# CITY OF ALBUQUERQUE

May 19, 2016

**Re: Dialogue Brewery**  
**1501 1<sup>st</sup> NW**  
**Traffic Circulation Layout**  
Engineer's/Architect's Stamp dated 5-18-16 (J14-D040A)

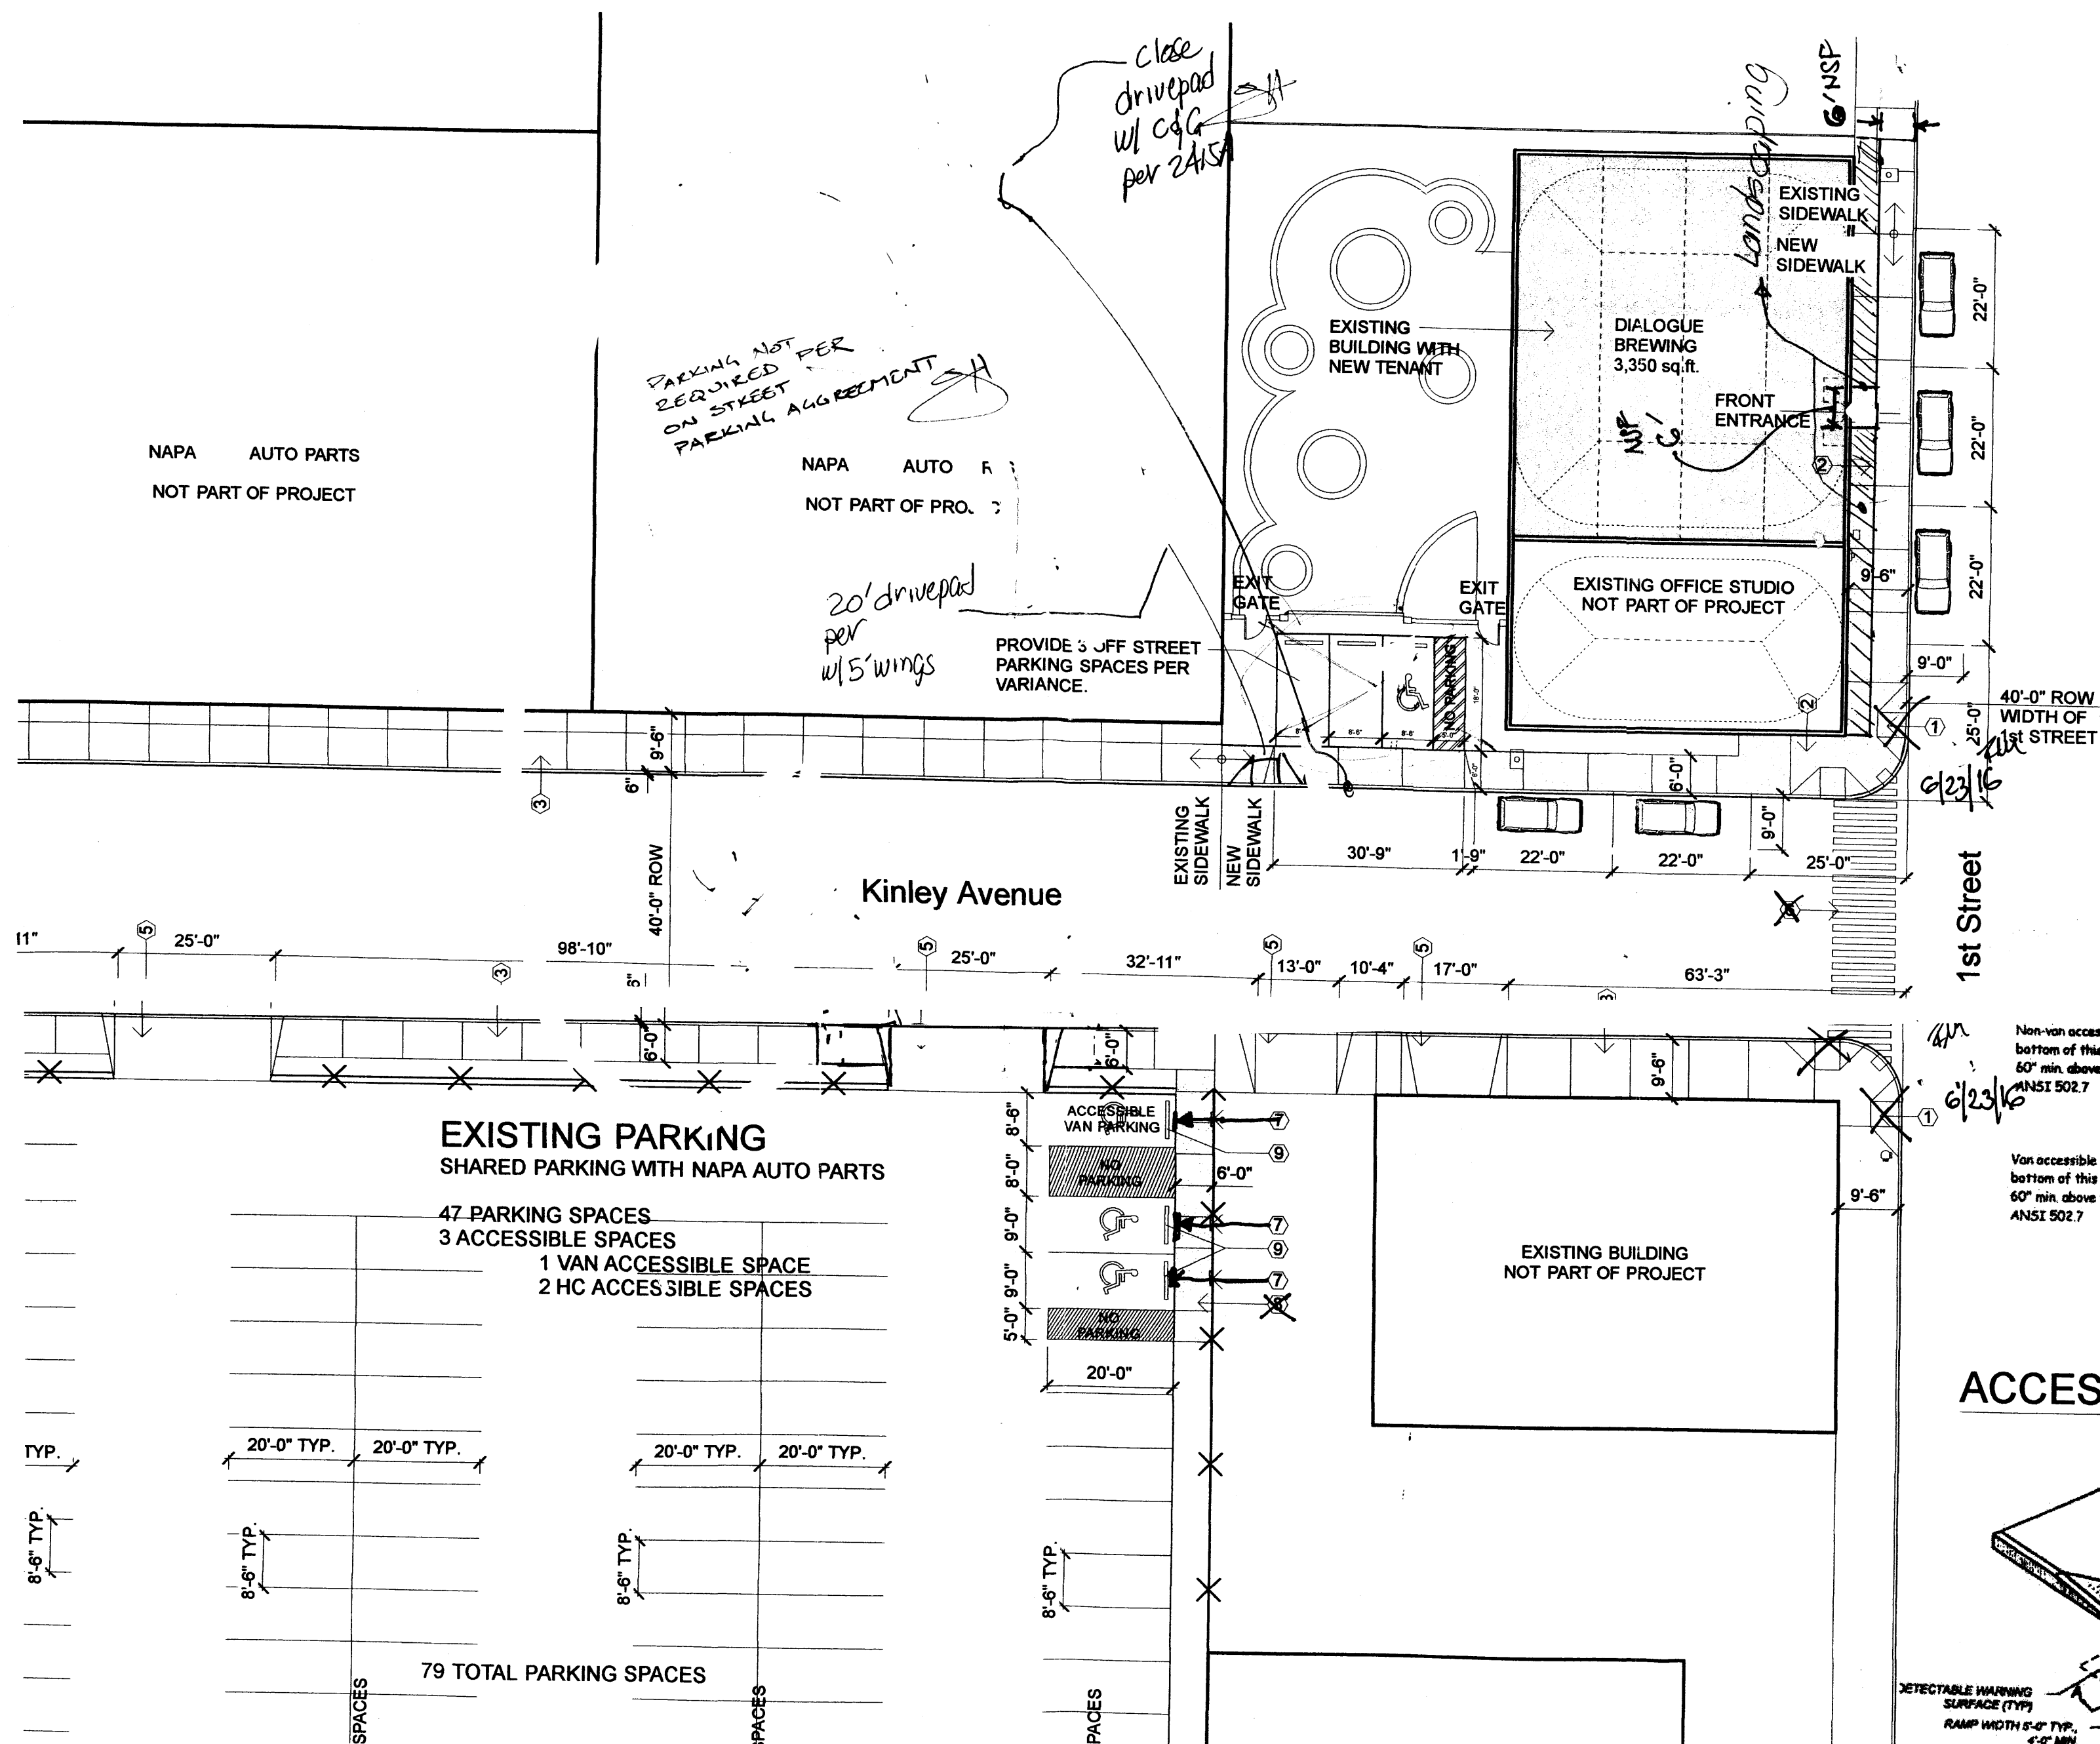
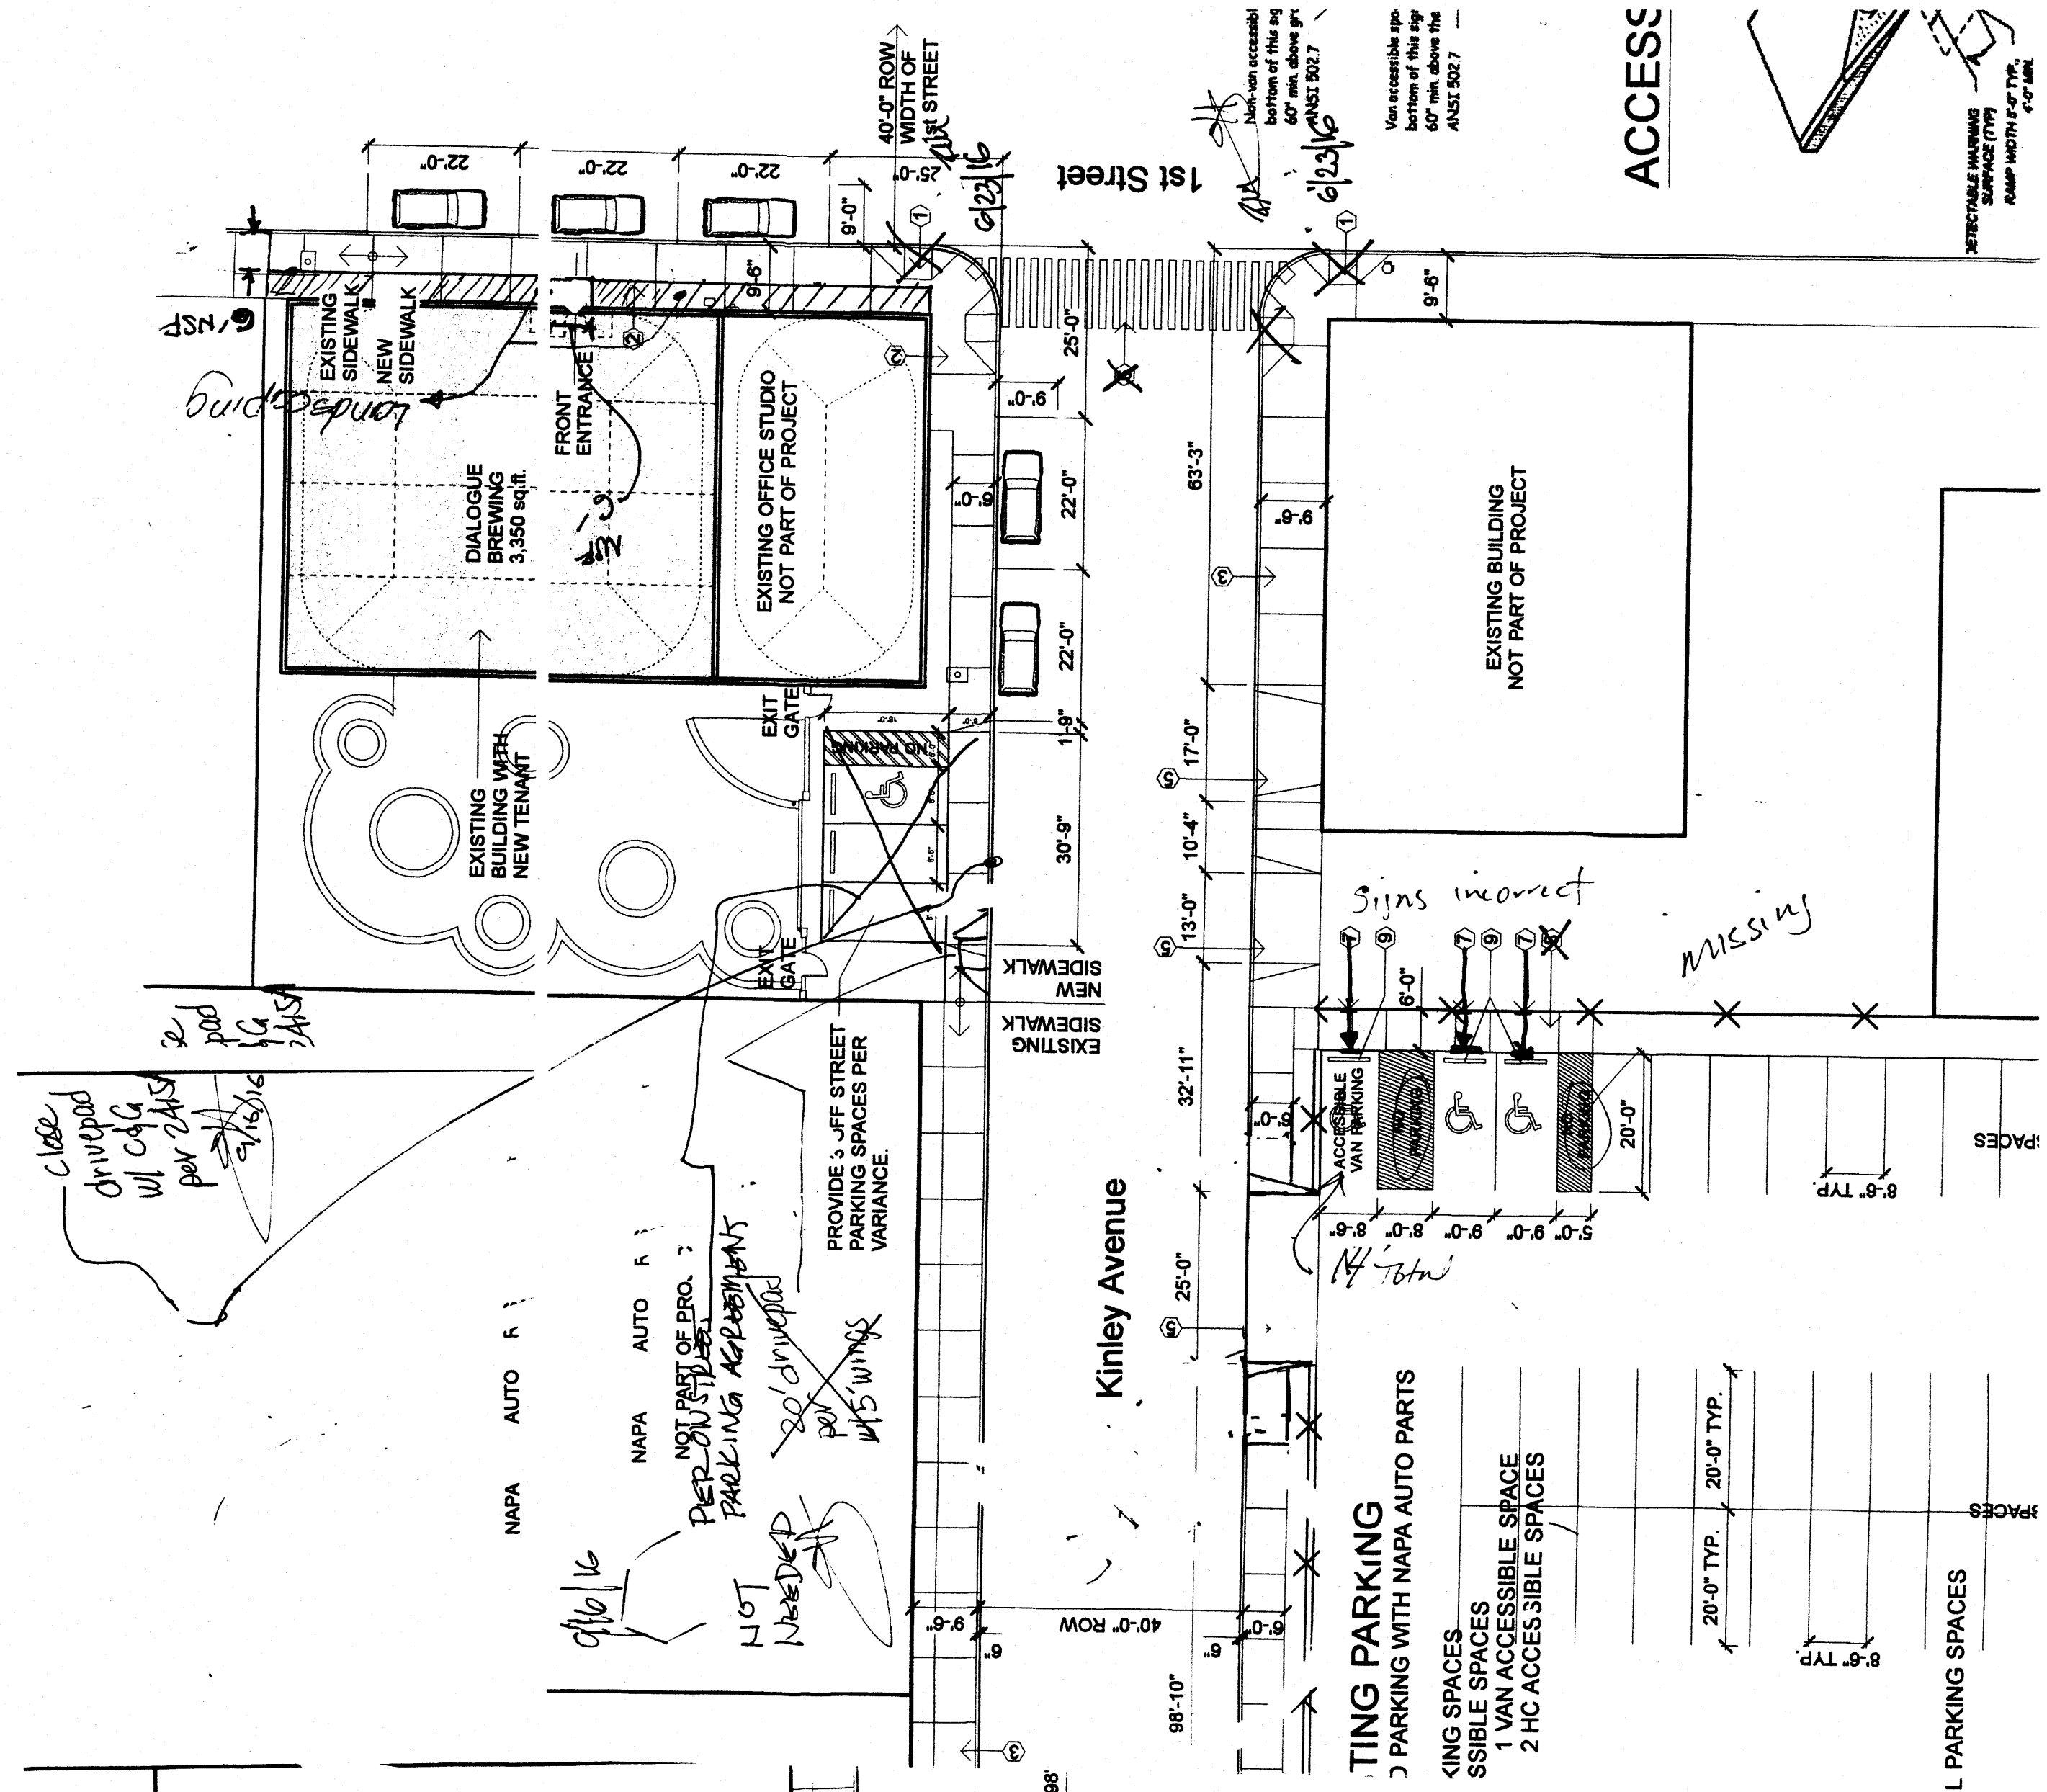
- **On-Street parking credit must be secured and the three parking spaces located on the south west corner of the site must be removed.**
- **The driveway providing access to those spaces must be replaced with standard curb, gutter and sidewalk.**
